**Subject:** 1 Eastfield Drive,West Bradford.

West Bradford Parish Council

PROPOSED SITE PLAN

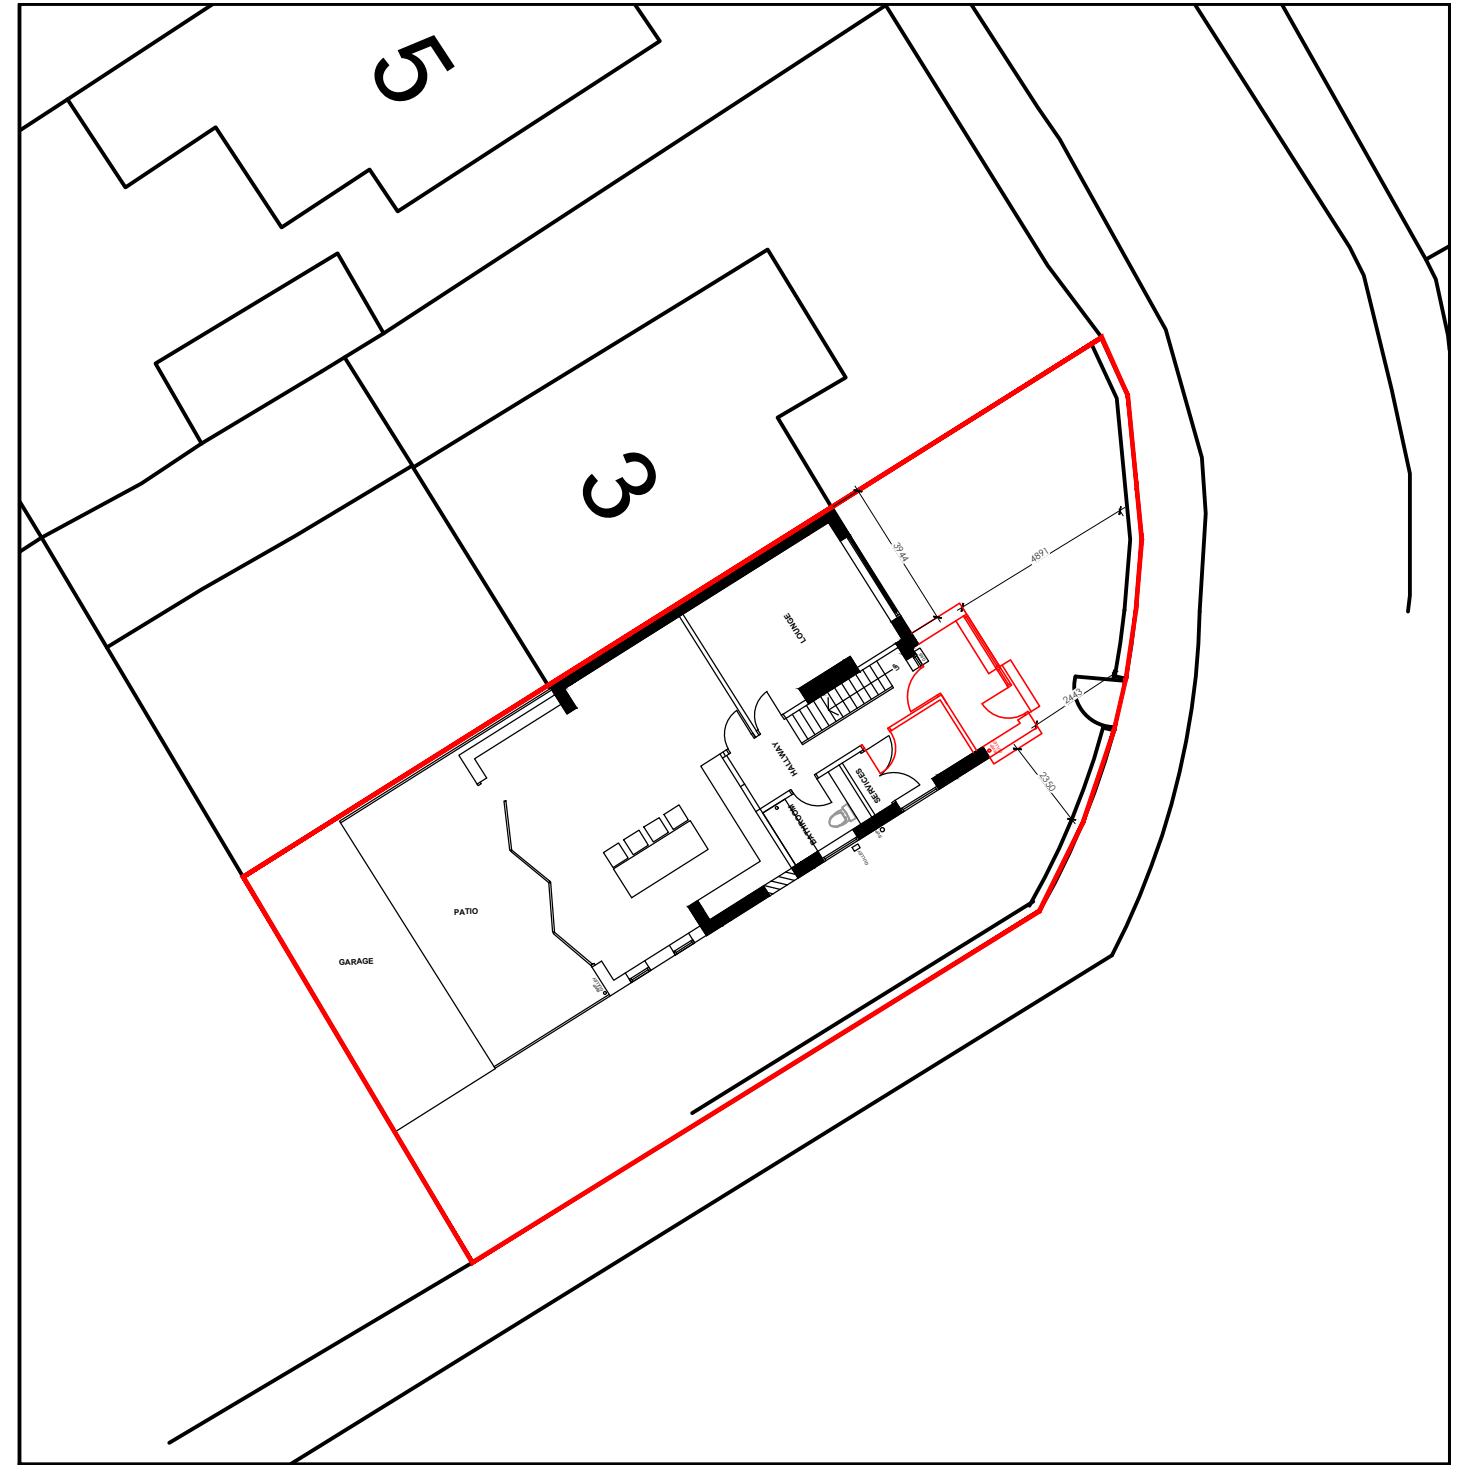
I have one comment on this application for planning.the loss of a parking space,it will mean 1 more car on the street.
